Your Ref EN010132

RE: Deadline 1 Response

Update of Development Consent Order and Protective Provisions

Canal & River Trust

Figure Cable Route Crossing Map			
Job West Burton Solar Scheme			
Client West Burton Solar Scheme			
Figure No.	1	Revision	A
		Date	27/01/2023
Drawn	KH	Checked	EB
		Scale	1:50,000 @ A3
Job No.	21-1098.03		Central GR
			485327E 381112N

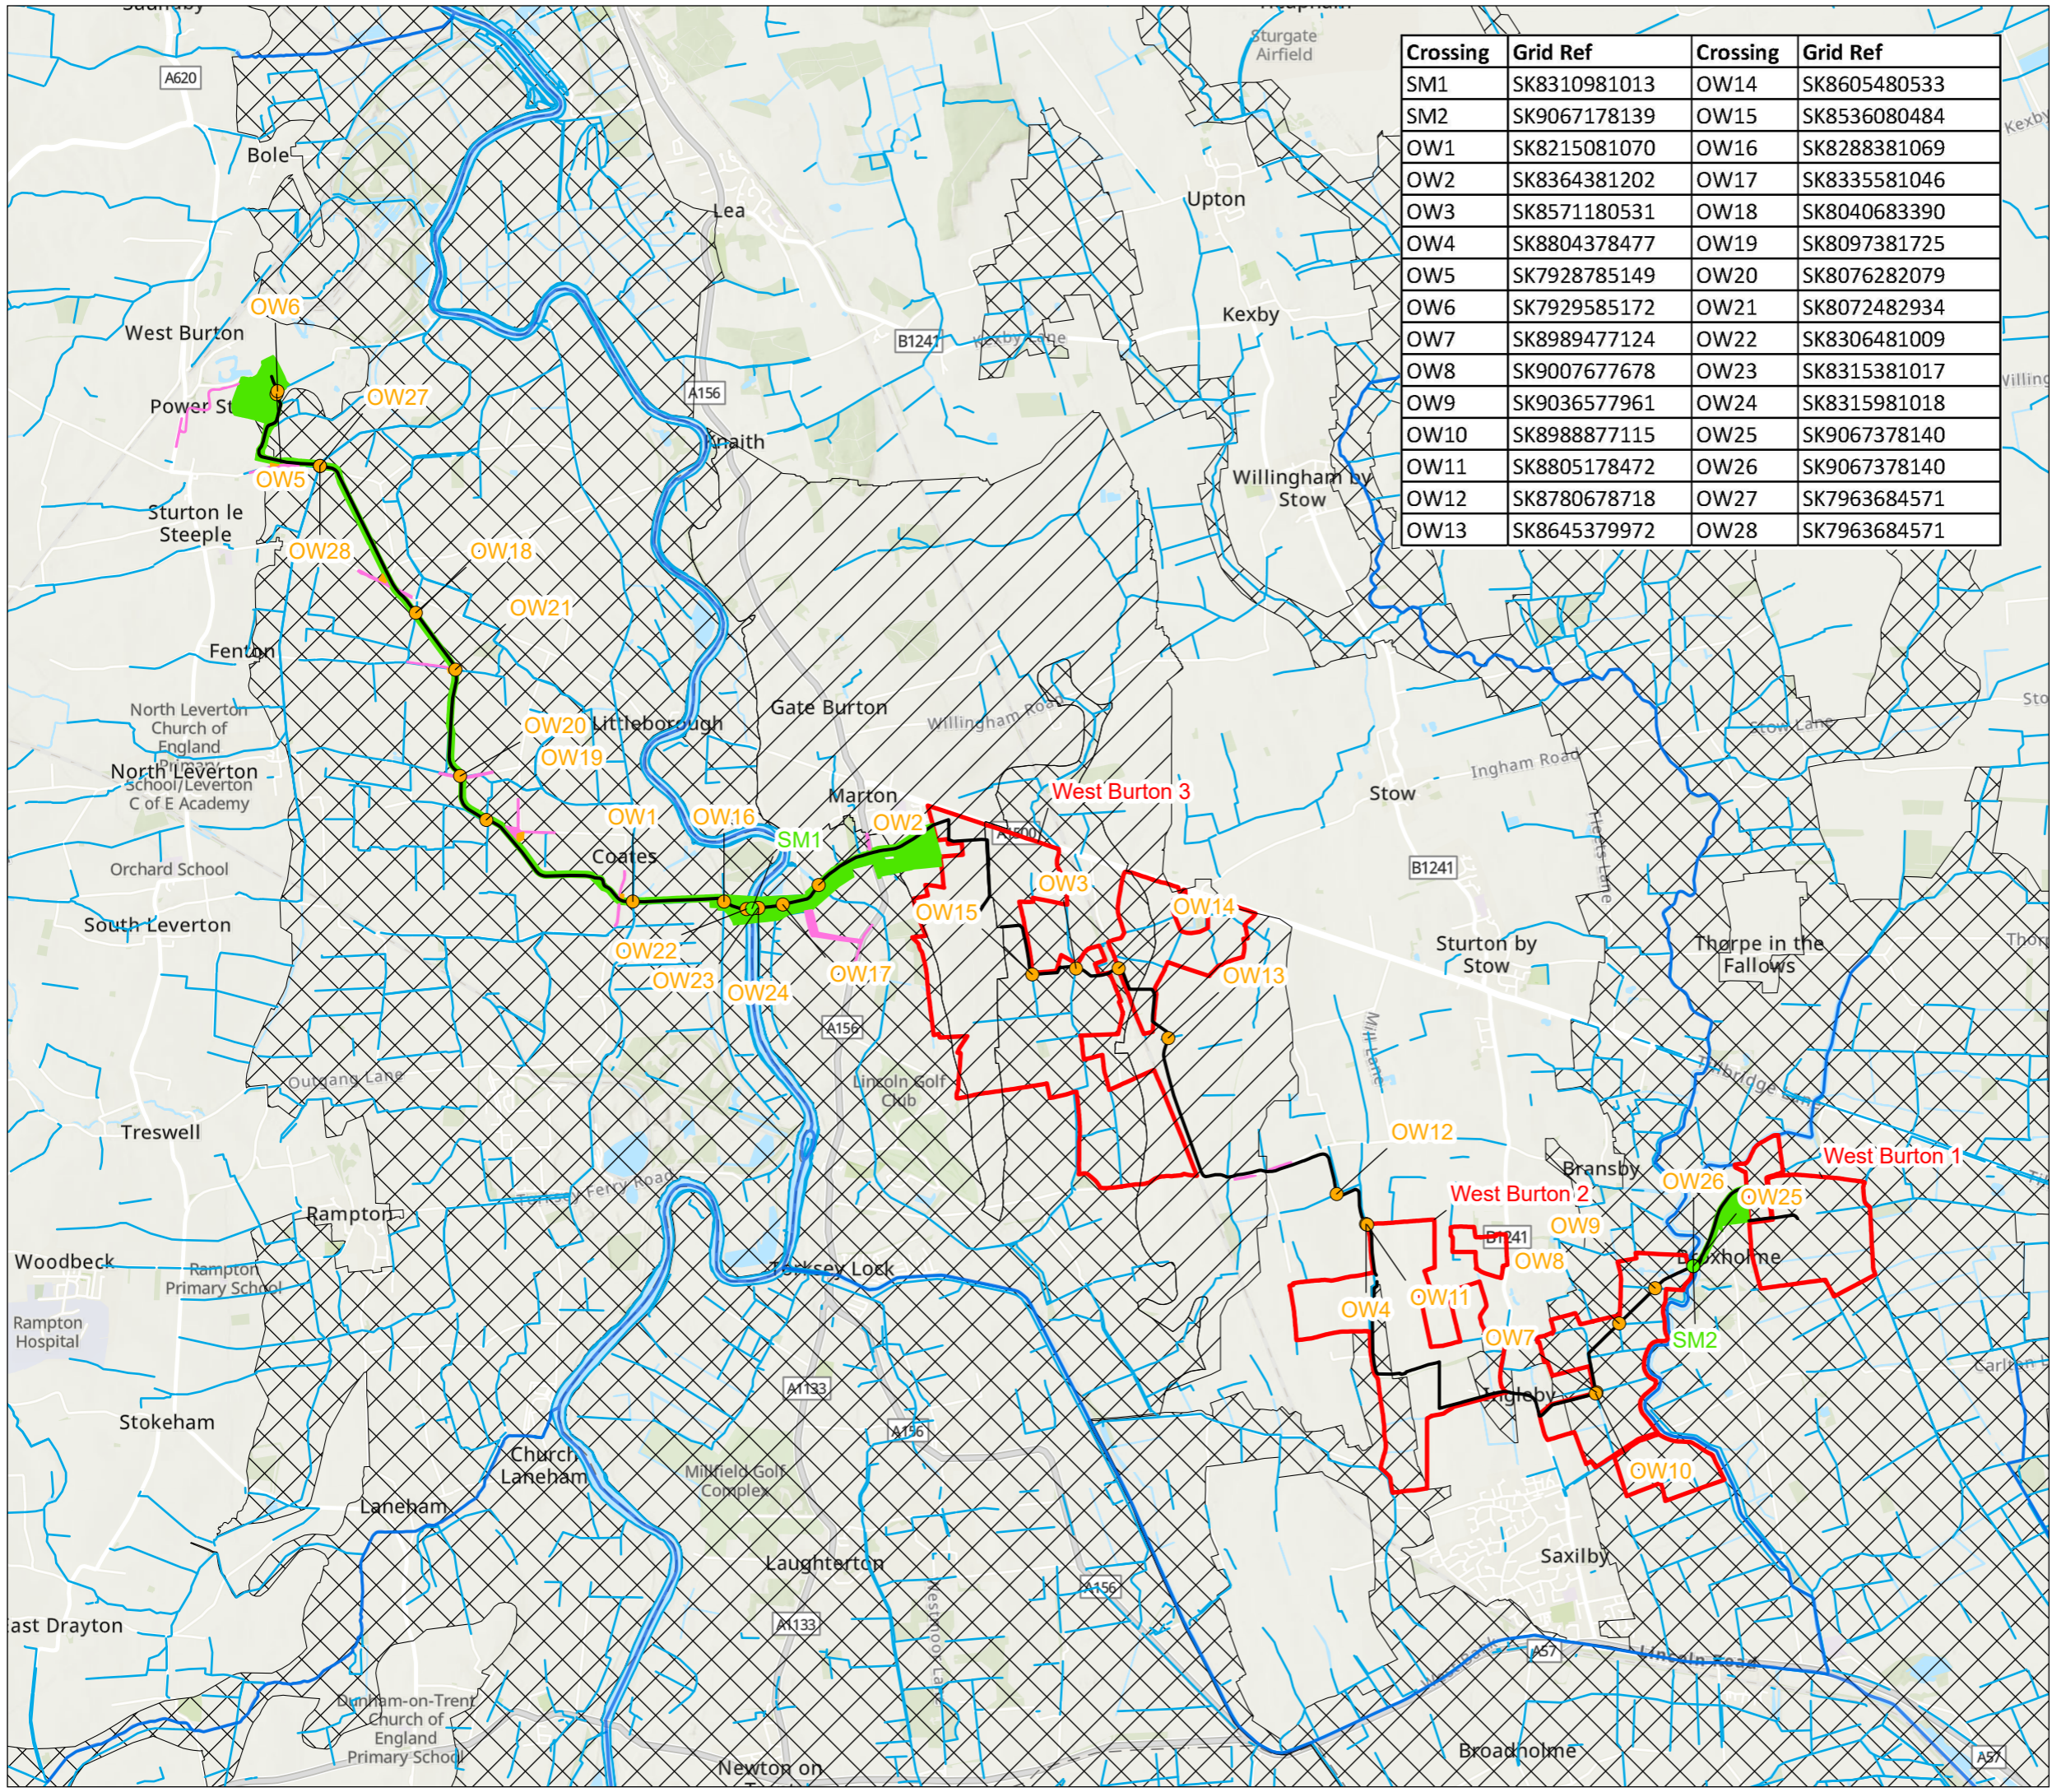
At the time we made our Relevant Representation not all of the Crossing Schedule document was available, and the Applicant has since submitted Crossing Schedule Revision A (AS-001). We continue to work with the Applicant to understand how the proposal will affect the Trust's dredging tip within Works package 5A. The Crossing Schedule suggests that the entry/exit pit for the Horizontal Directional Drill (HDD) will be located south of the dredging tip and the open cut method used as the cable route continues towards West Burton from the River Trent. The proximity of the works to the hedgerow (H146 on the Important Hedgerows Plan (**WB2.9**)) along the southern boundary of the dredging tip site and its L shape bund to the north side of this hedgerow will need to be included within the Crossing Schedule if the cable route or its associated ground works are to intersect with these Trust assets.

Whilst HDD methods are proposed, we can find no reference to the proposed depth of the drilling beneath the riverbed as was provided with the Cottam and Gate Burton projects. We would encourage the Applicant to maintain the same minimum and maximum drill depths beneath the River Trent as the other projects as parameter documents are drafted.
